SSD 9344 – KENT ROAD PUBLIC SCHOOL RE-DEVELOPMENT – ENVIRONMENTAL IMPACT STATEMENT (EIS)

ATTACHMENT A
ENVIRONMENT PROTECTION AUTHORITY COMMENTS
KENT ROAD PUBLIC SCHOOL RE-DEVELOPMENT

PROJECT No
17058
DRAWING No
SSDA-0400

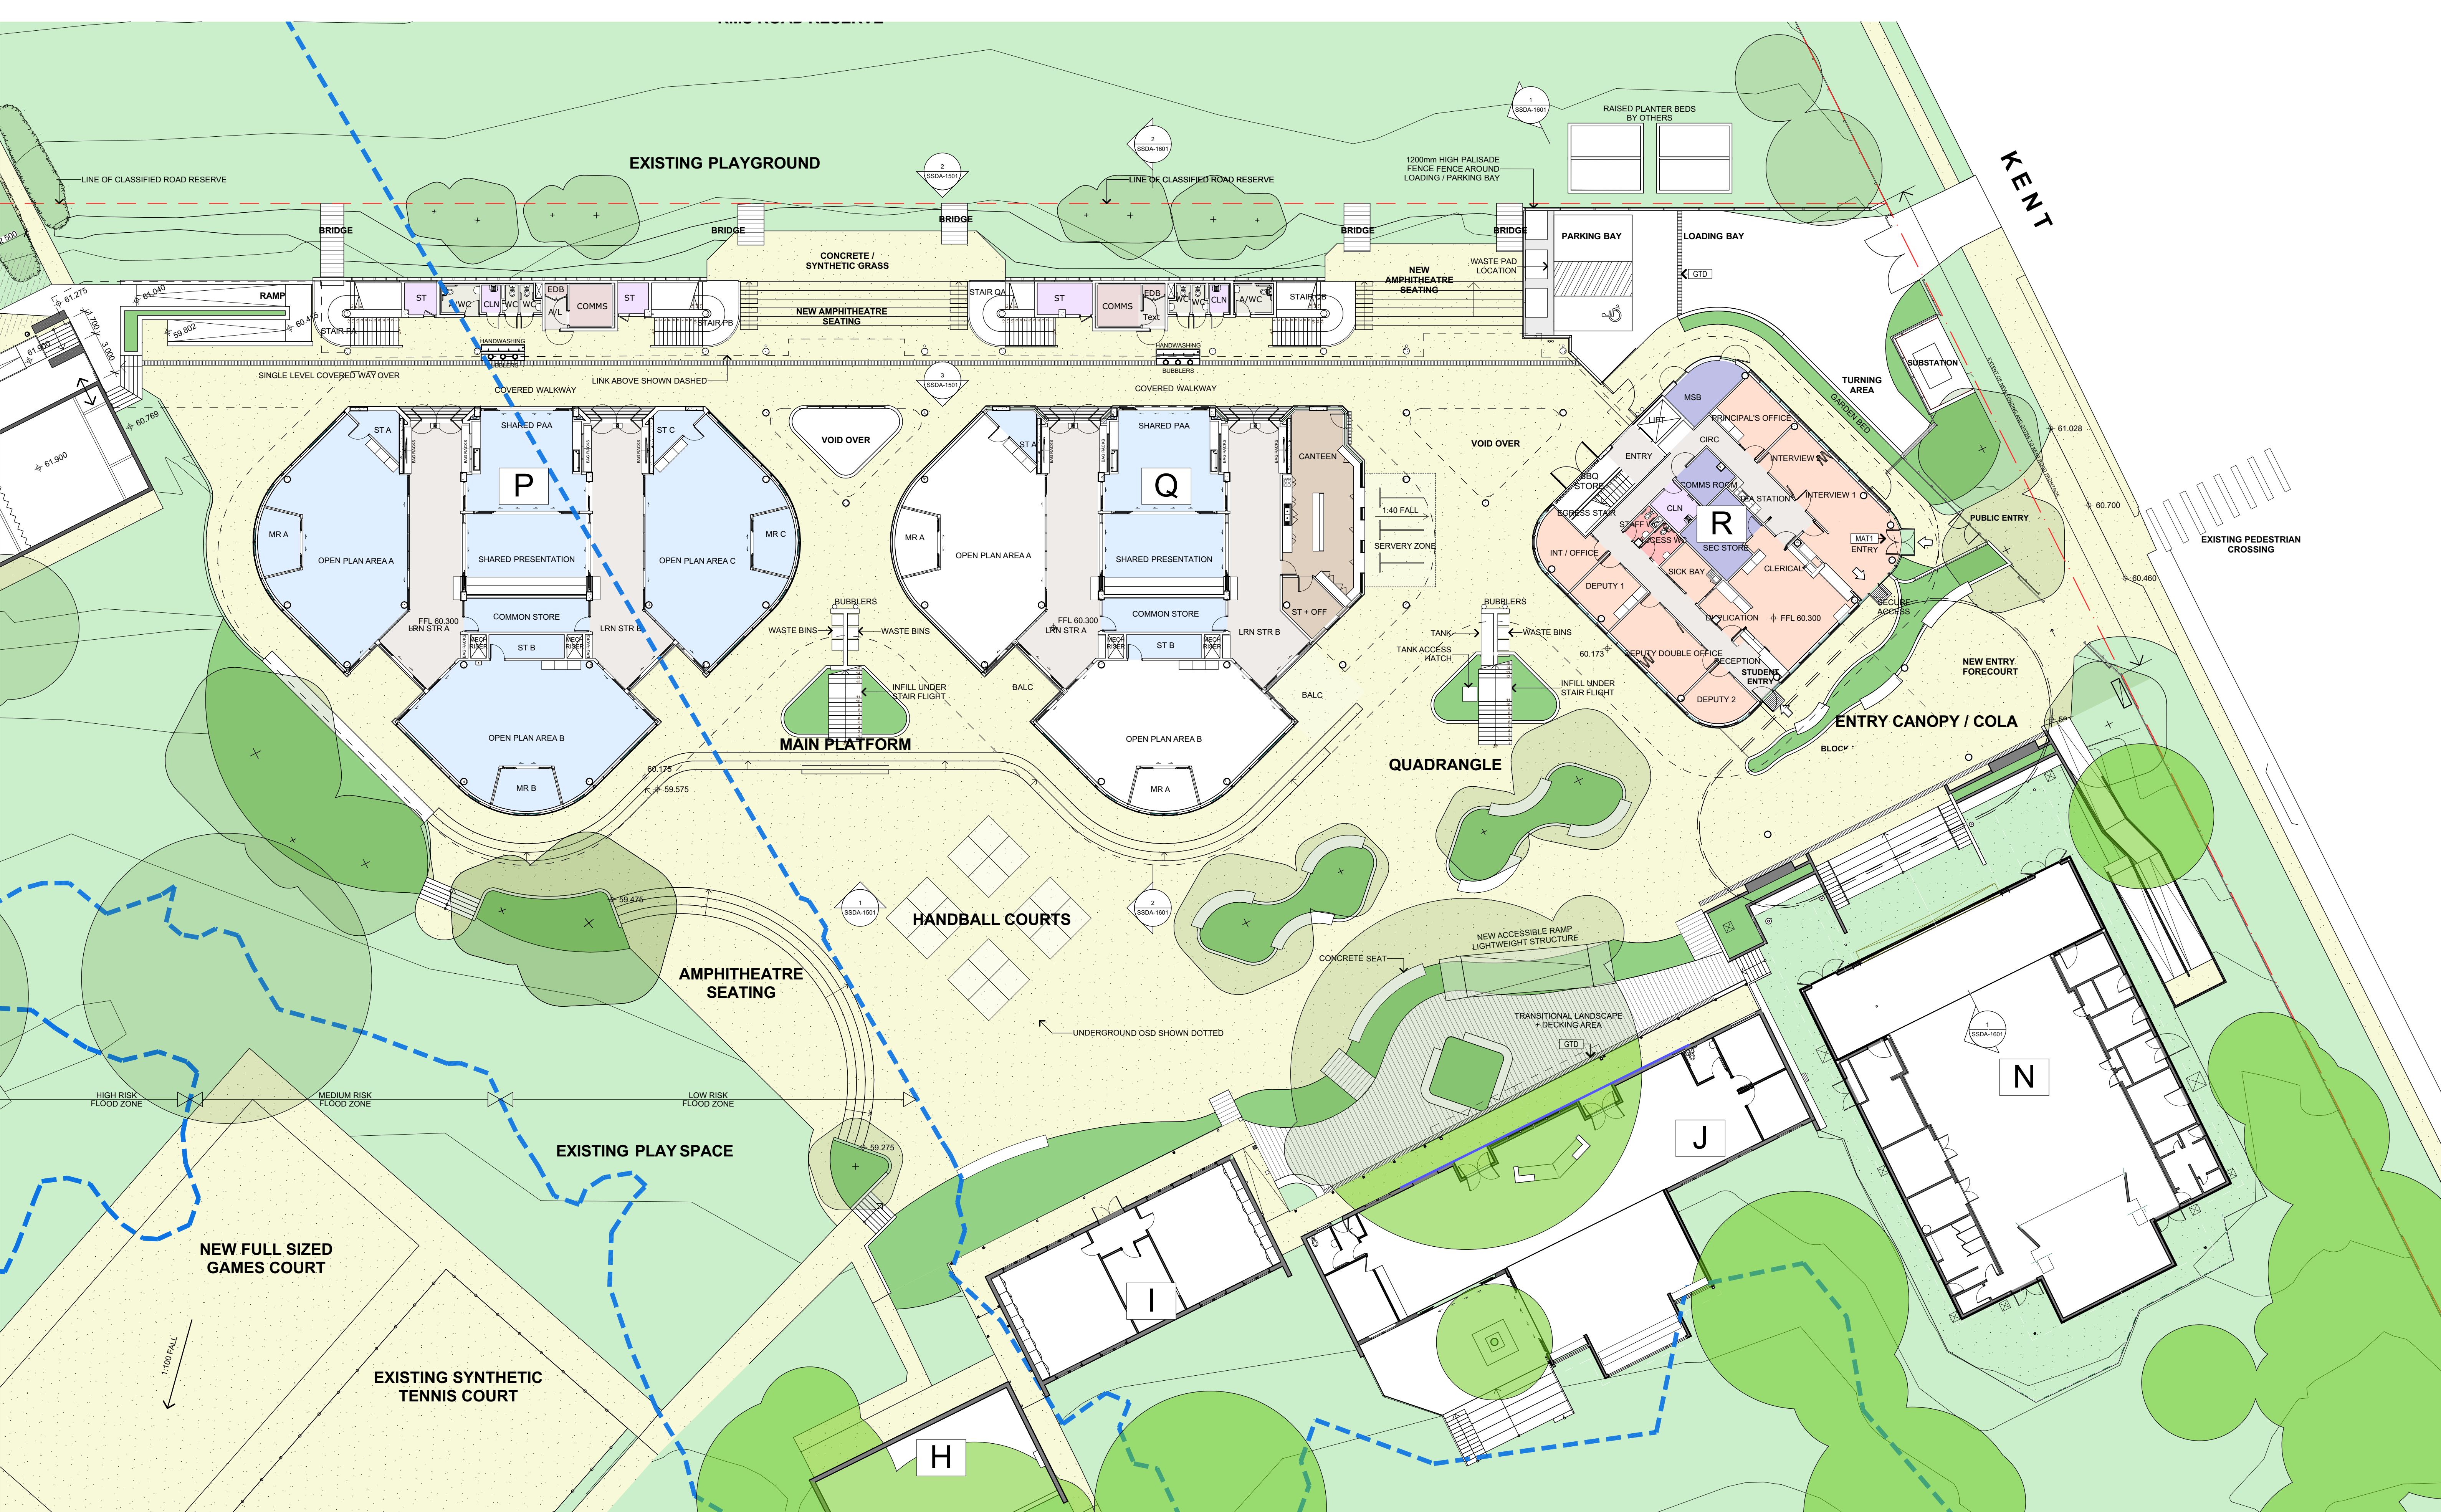
Section 3.2 of the EIS describes the development site as the whole of the school campus. However, EIS architectural drawing SSDA-0400 indicates that the development site is proposed to be limited to northeast corner of the school campus which is referred to as the "... buildable area ..." shaded orange on Drawing SSDA-0201. The EPA notes that the overall school campus includes outdoor sports courts and the existing school hall (i.e. Block N) which adjoins the proposed new structures. The EPA considers that the project is an integral part of the overall campus and is unclear what practical distinction might be drawn between operational environmental impacts (e.g. noise, cumulative) from activities on the "... buildable area ..." and those from the overall school campus. Accordingly, the EPA has reviewed the impacts of the proposed works as an integral part of the overall campus.

Section 4.0 of the EIS indicates that the project includes 'site preparation' but is unclear about whether site preparation includes demolition of existing structures (i.e. G, F K and L), infrastructure and underground services (and associated site disturbance) within the so-called "... buildable area ..." (viz drawing).
